Fire Marshal Division

**Re: Carolina Wildlife Park
1096 Patterson Rd.
Broadway, NC 27505**

Application Number BCOM1812-0001

1
A **FIRST FLOOR PLAN**
SCALE: 3/8" = 1'-0"

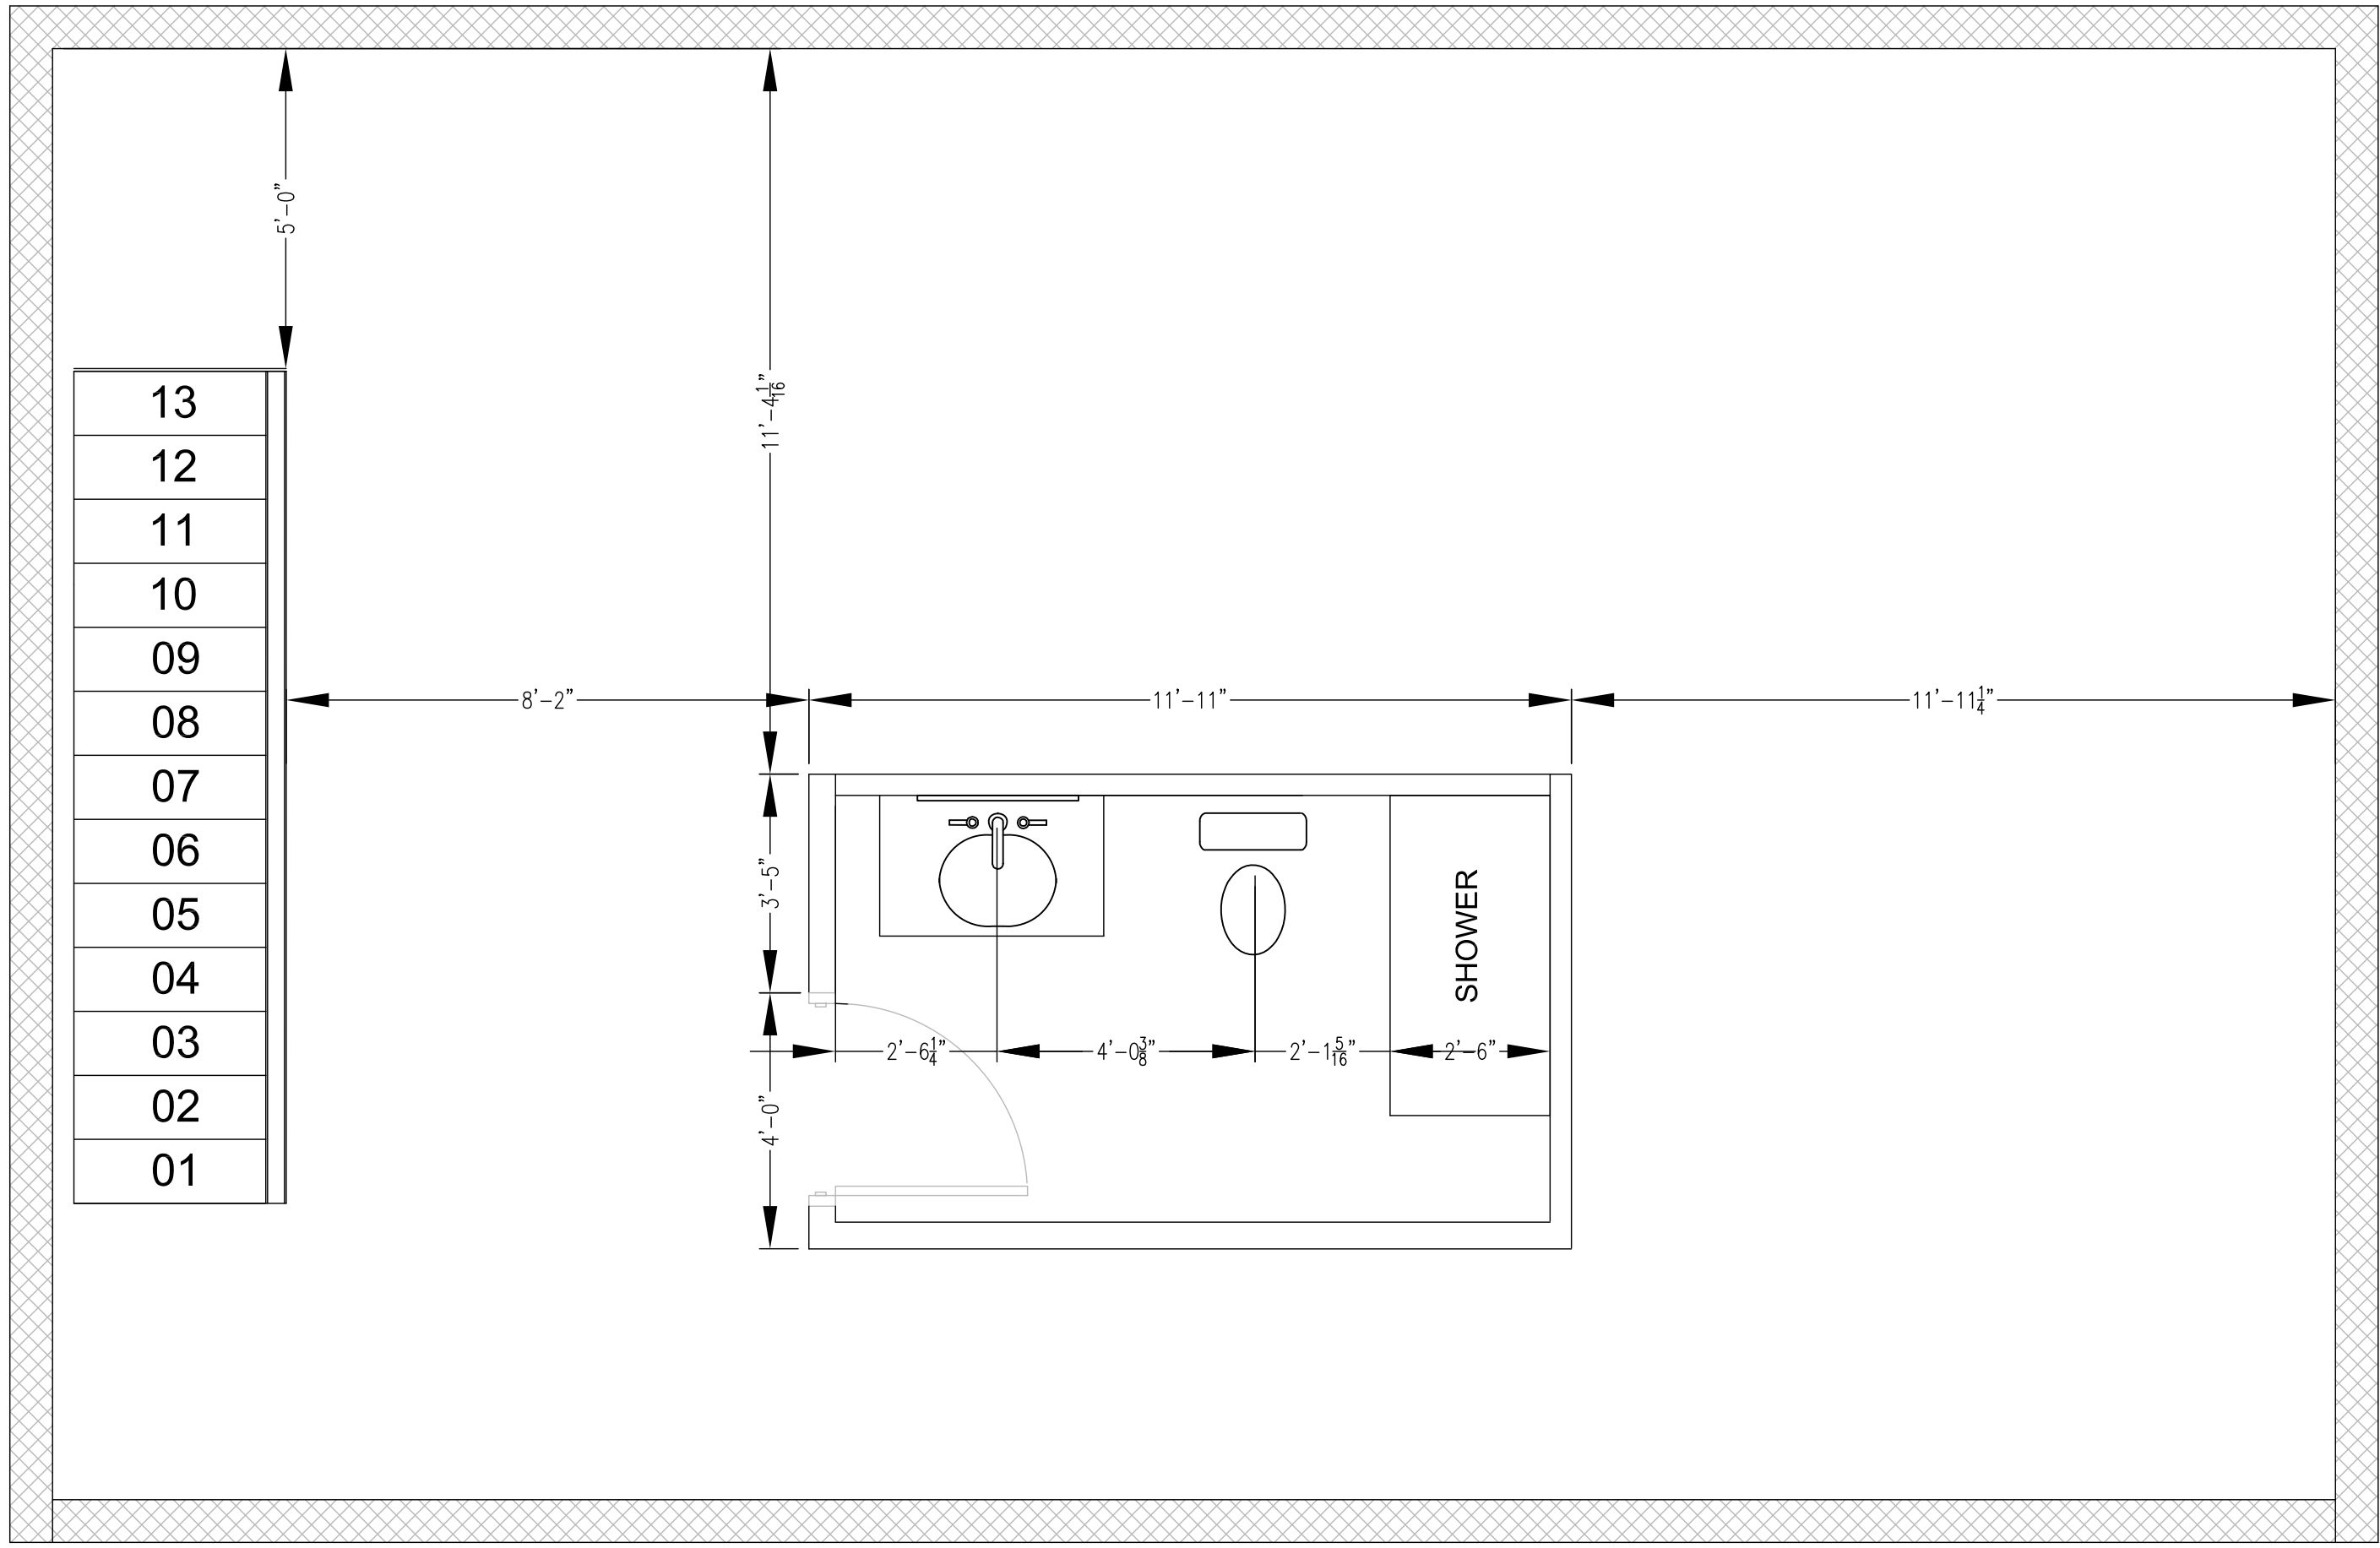
- **1006.1 Illumination Required**
 - The exit discharge shall be illuminated at all times the building spaces served by the means of egress is occupied

Illumination level in all areas of the means of egress shall not be less than 1 foot-candle at the walking surface and shall have emergency power supply.
